From: Sue Howell
Sent: 27 March 2019 14:42
To: Planning.Responses
Cc: Anita Gardner
Subject: RE: Planning Consultation on: CM/4/19/PL

Comment from Greenspace

APPLICATION NO: CM/4/19/PL

Description of Works: Construction of a crematorium comprising of a crematorium building & associated structures, car parking, access & landscaped spaces.
This application is a Departure from the Development Plan.

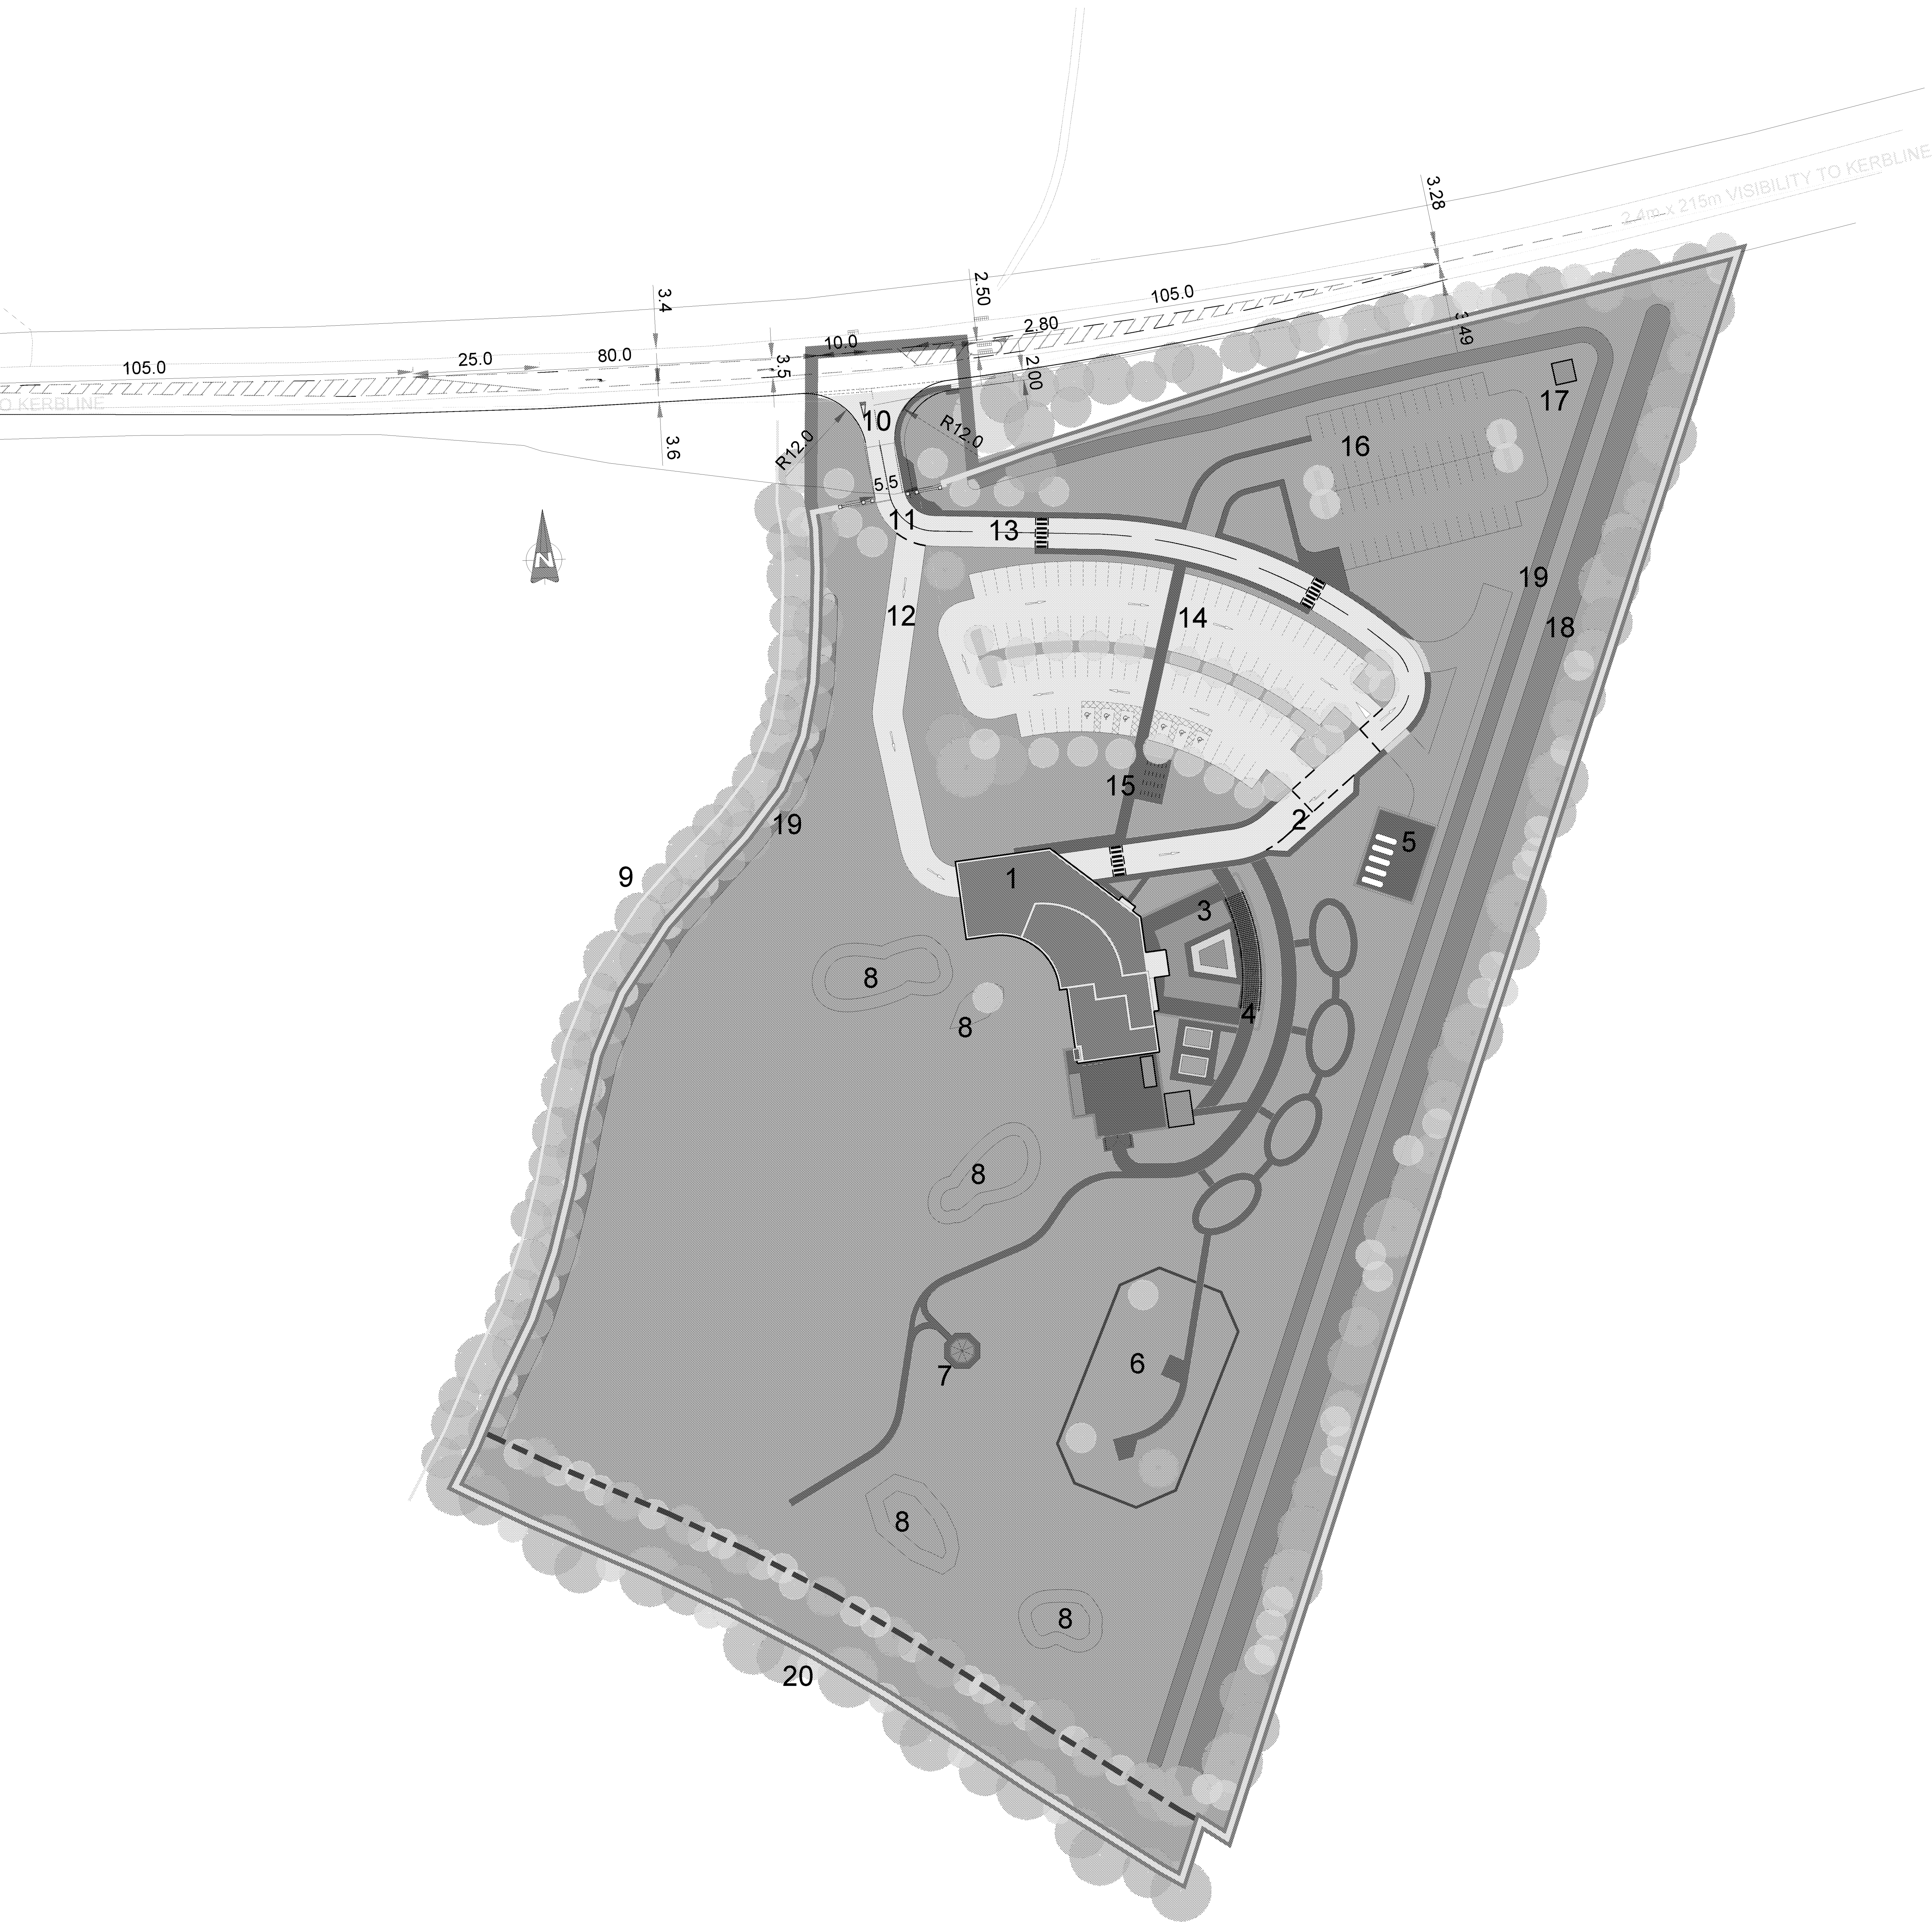
The proposals under CM/4/19/PL are for a crematorium and associated infrastructure so no public open space is required on site, other than the creation of grounds and gardens suitable for location and application of these proposals. There would be the need for site screening which some detail has been given in proposed planting scheme drawing CS.642.01.Rev C and schedule CS.642.02.Rev C. It is difficult to assess whether the screen planting proposed would be suitable and sufficient in quantity as there is no existing to be retained planting presently shown to this drawing.

My observation and comment would be that whilst the shrub mix, shelter belt and native woodland mixes would be suitable species wise, that they need to be represented alongside retained vegetation, particularly along the boundaries and eastern boundary edge.

The landscaping indicated to the carpark and building surrounds would appear to be sparse and not offering a very soft or ornamental approach to the crematorium buildings. Likewise the area shown as 'scattering area with seating' is shown as simply a grassed area with two trees. I don't think in practice this would suffice or be a very aesthetically pleasing area.

In conclusion I would have to recommend that the **landscape information submitted within this application CM/4/19/PL is significantly insufficient** in detail and that further should be submitted for approval and as a minimum conditioned with any decision. I would have to recommend a landscape objection to the information as submitted to date.
